13th October 2021

Reference: A47 - A11 Thickthorn Junction written representation

Appendix 1: Proposed Site Layout

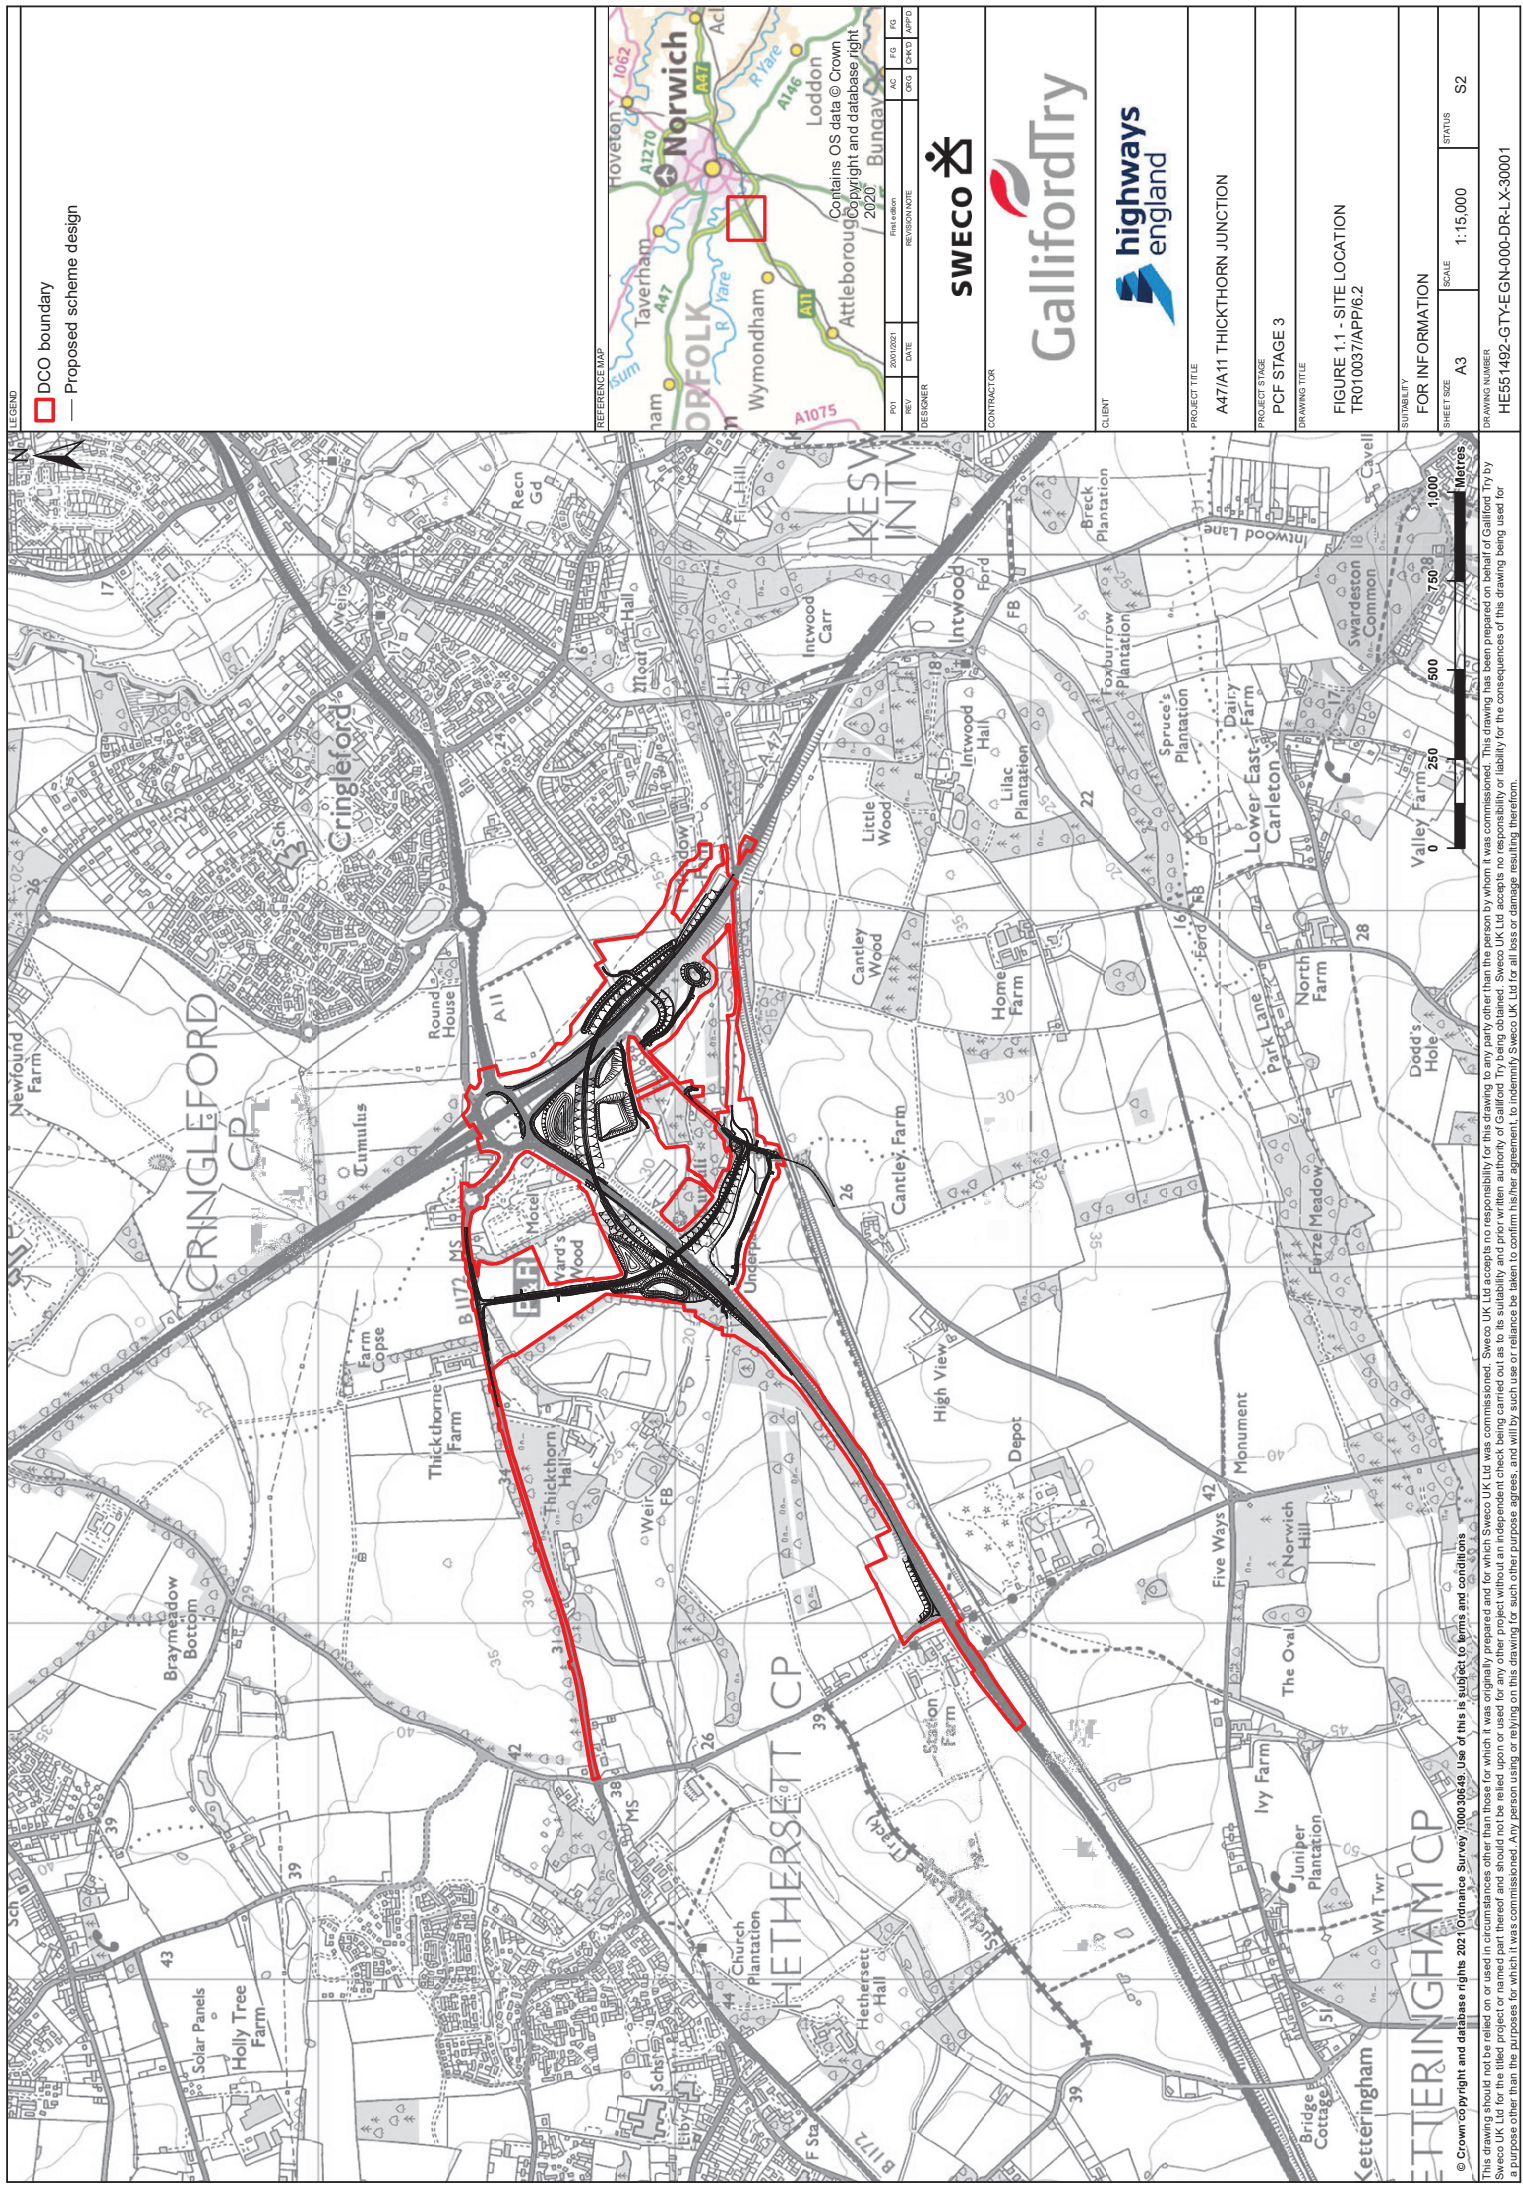
The proposed scheme will result in the loss of two veteran oak trees recorded as T13 and T14 within the Arboricultural Impact Assessment Report [APP-085], alongside likely detrimental impact to a number of other veteran trees adjacent to the scheme boundary. Therefore, the Trust would like to lodge **an objection** to this development.

The following scheme will result in the direct loss of two veteran oak trees (T13 and T14), as well as the removal of several other mature trees of considerable size and/or displaying veteran features. In addition, the scheme will likely result in significant impact to the following trees:

- T1 is within close proximity to the proposed road infrastructure and will likely be subject to root damage during construction. The RPA of T1 has also been capped at 15 metres, so does not fully account for the root spread of the veteran tree.
- T2 is also within close proximity to the proposed road infrastructure, which could result in root damage during construction.
- T5 and T6 will be subject to root encroachment during construction of the proposed road, which could result in root damage. The RPA of T5 has also been capped at 15 metres, so does not fully account for the root spread of the veteran tree.

In summary, the Woodland Trust requests that all veteran trees are retained and afforded a Root Protection Area (RPA) in line with Natural England's Standing Advice, and further investigation into the potential ancient woodland status of Cantley Wood is explored.
